RE: Responses to Comments
Dutch Bros Coffee
1125 Snow Vista Boulevard Southwest, Albuquerque, New Mexico 87121
Our Job No. 23007

We have revised the plans and technical documents for the above-referenced project in accordance with your comment letter dated October 19, 2023. Enclosed are the following documents for your review and approval:

The following outline provides each of your comments in italics exactly as written, along with a narrative response describing how each comment was addressed:

C2.0

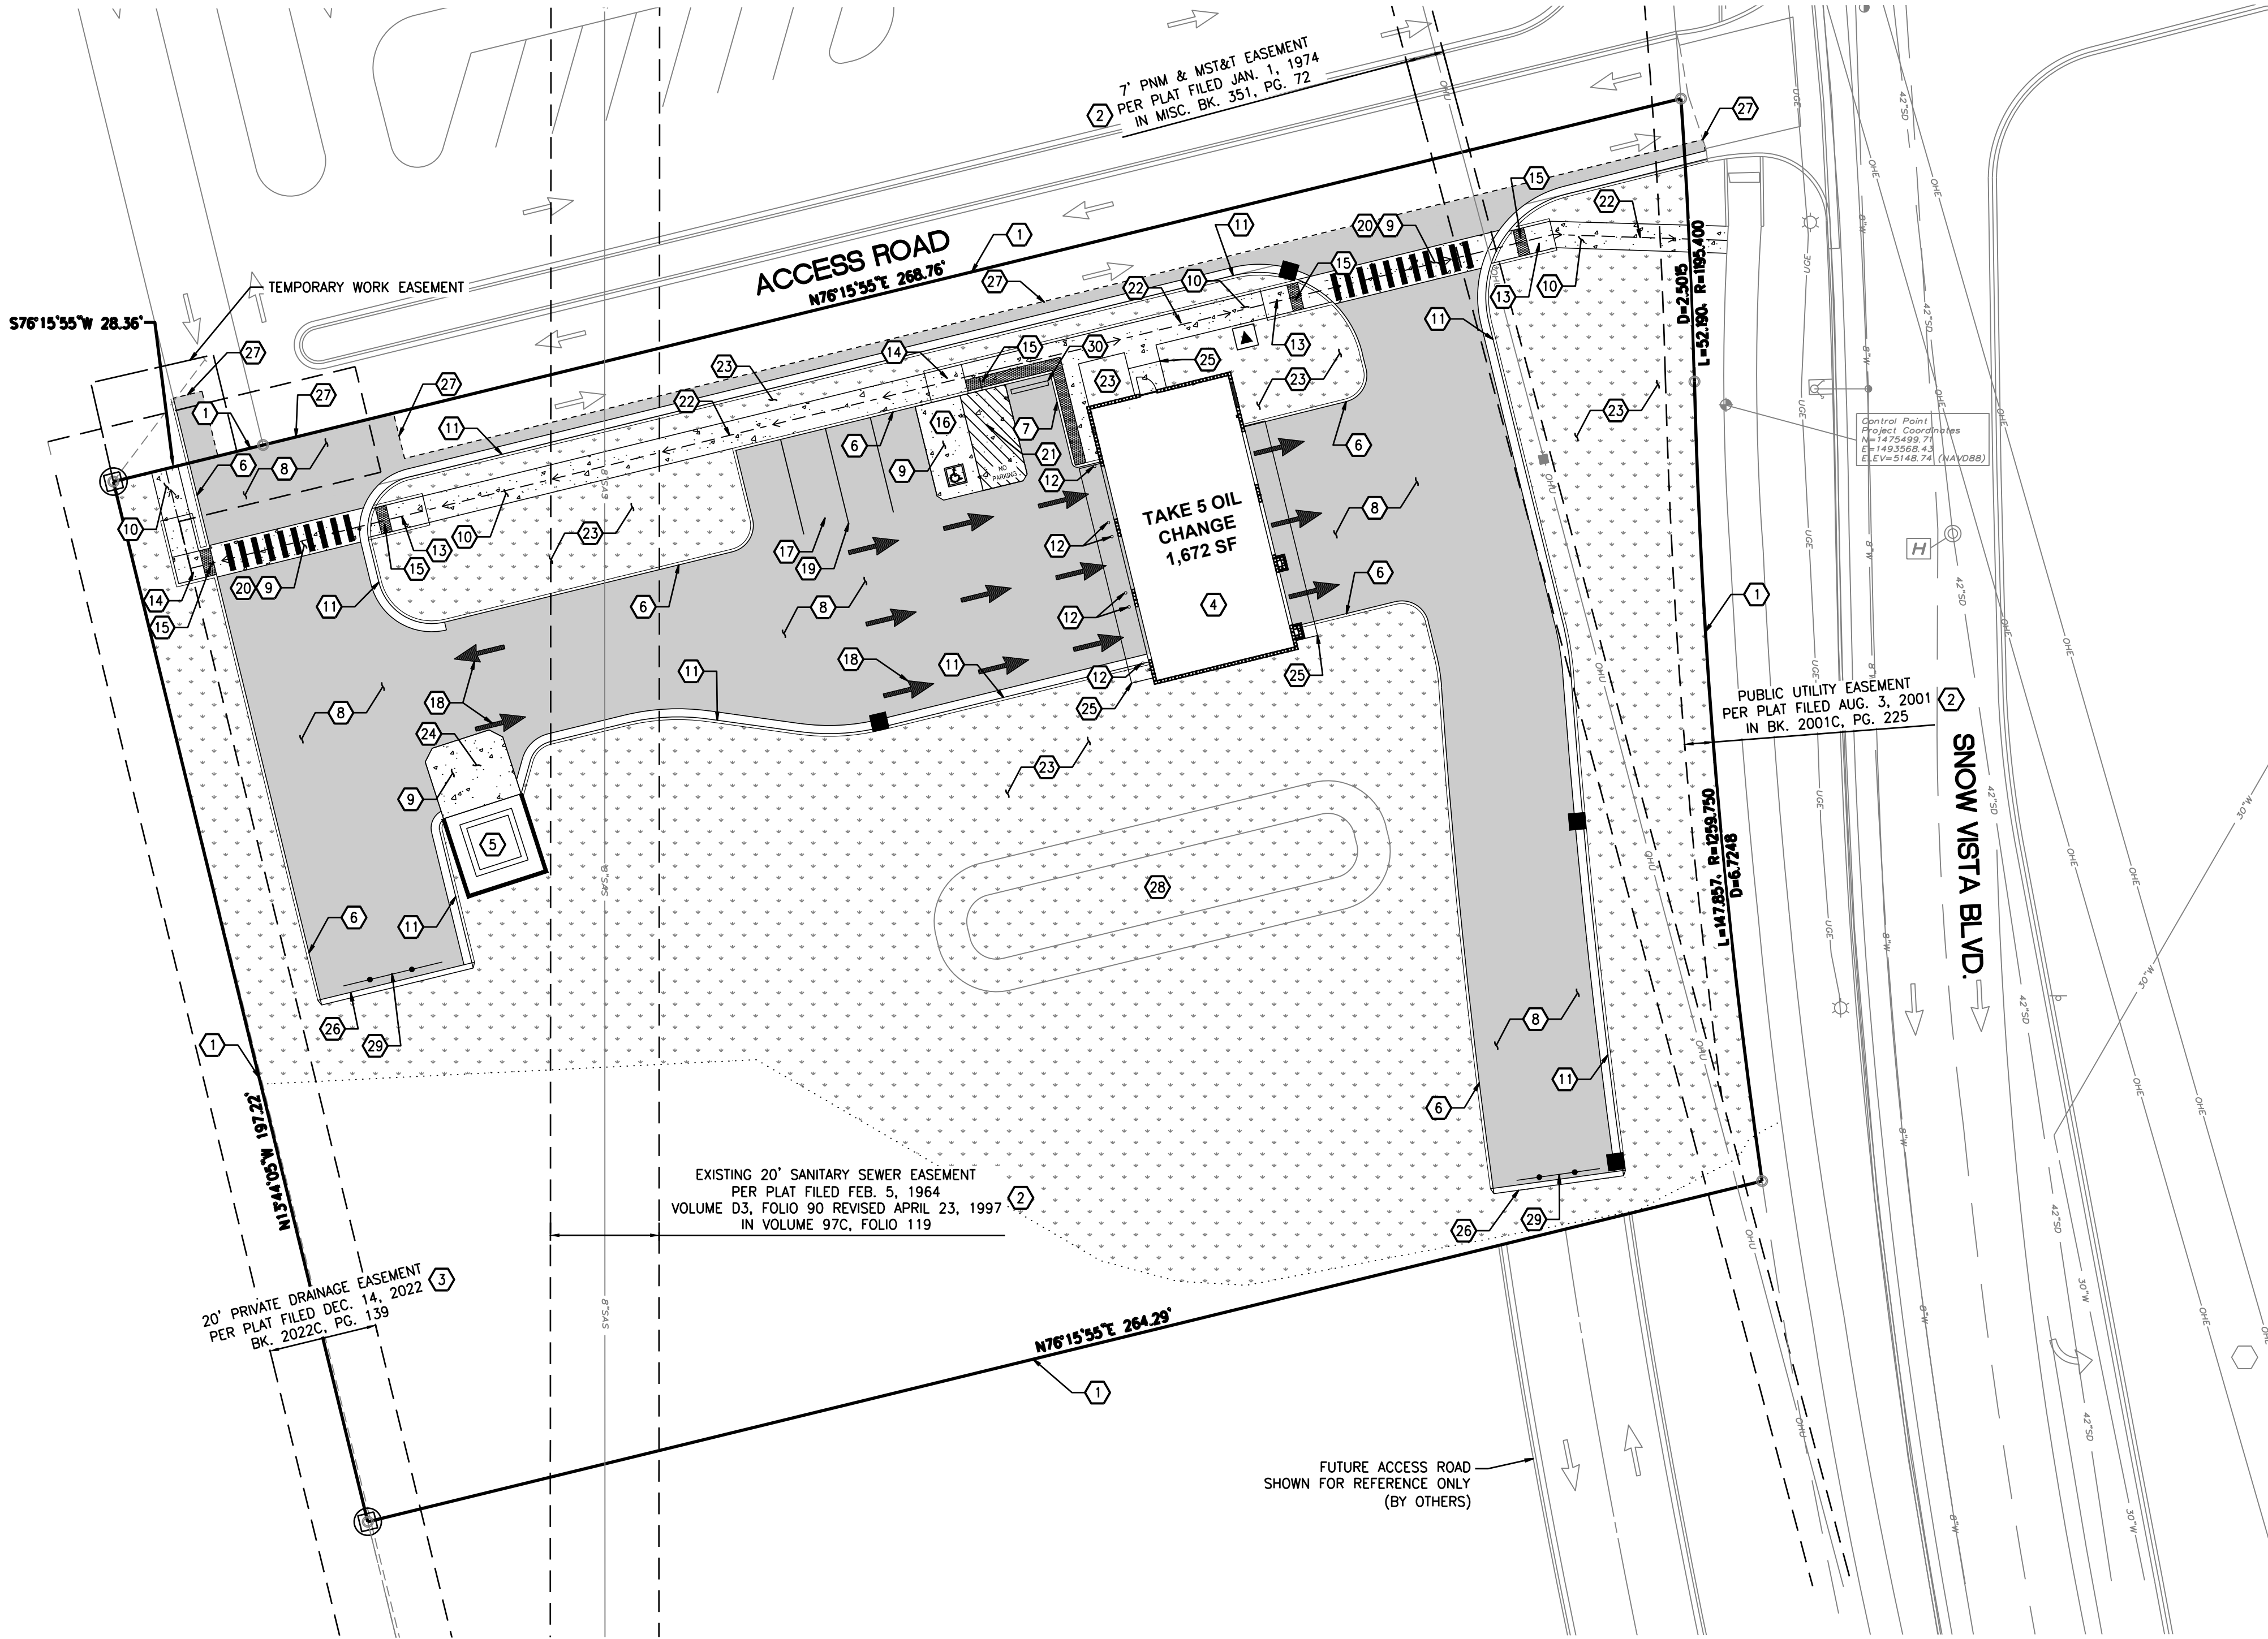
1. *Please show a vicinity map and the parking calculations table on the site plan sheet C2.0.*

4. *Please show on the site plan the existing site access and sidewalk width.*

5. *Show all drive aisle widths and radii. Some dimensions are not shown.*

Response: The Vicinity Map and parking calculations have been added to Sheet C2.0.

Response: The existing sidewalk width and access road width are shown on the plans.

Response: the drive aisle widths and radii have been added.
